Re: Response to CA017-007 (Critical Area Determination for 4634 E Mercer Way)  
C/O: Robin Proebsting

**Subject: Response to Review Comments  
Proposed Single-Family Residence  
4634 E Mercer Way, Mercer Island, WA**

A1.01

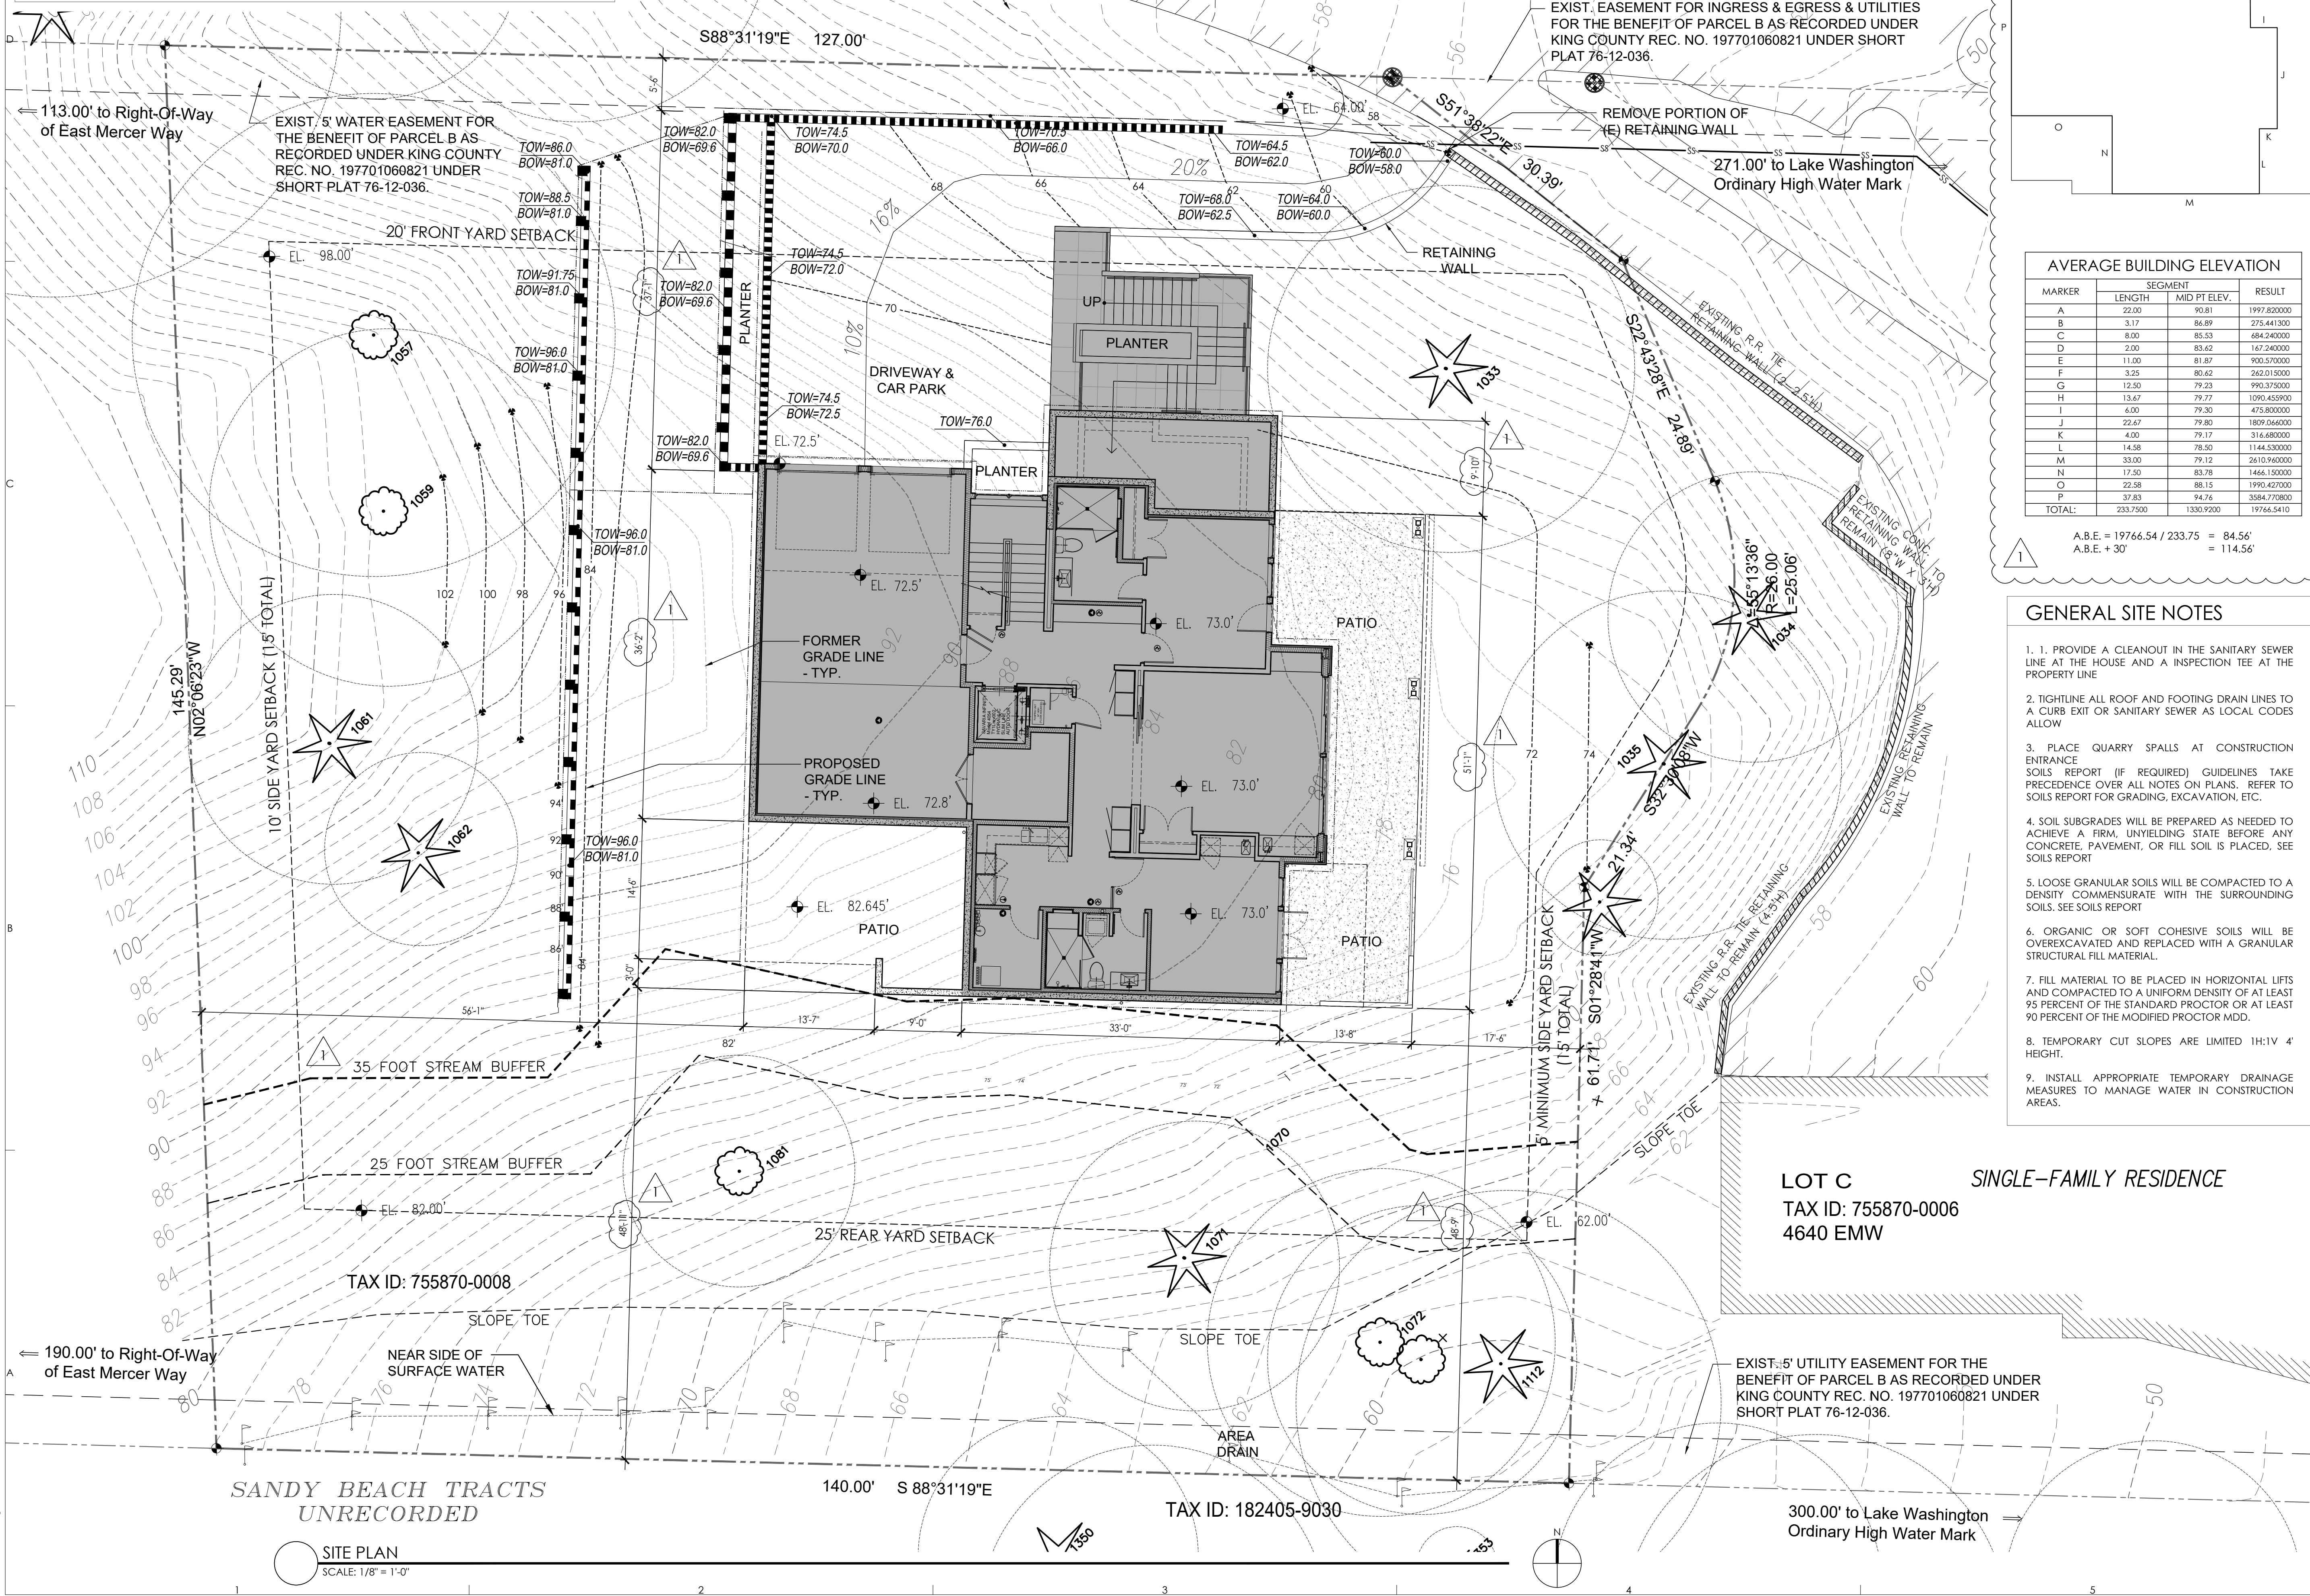
2. *Sheet A1.01 shows watercourse delineation flags. Sheet 3 of 6 of the civil plan set submitted for permit 1507-166REV proposes drainage infrastructure in what appears to be the same area as the watercourse (in the southeast corner of the site). In your resubmittal, please provide a sheet showing the location of the proposed drainage infrastructure in relation to the delineated watercourse.*

- a. *Based upon a review of the current plan set, it appears that work is proposed within the watercourse channel (on lands covered by water) and consequently a SEPA review is required. Please apply for a SEPA review, or modify the proposed design to avoid work on lands covered by water.*

**Work in the watercourse channel is no longer proposed. The tightline storm system will be laid at grade, therefore eliminating any impacts to the watercourse or its associated buffer.**
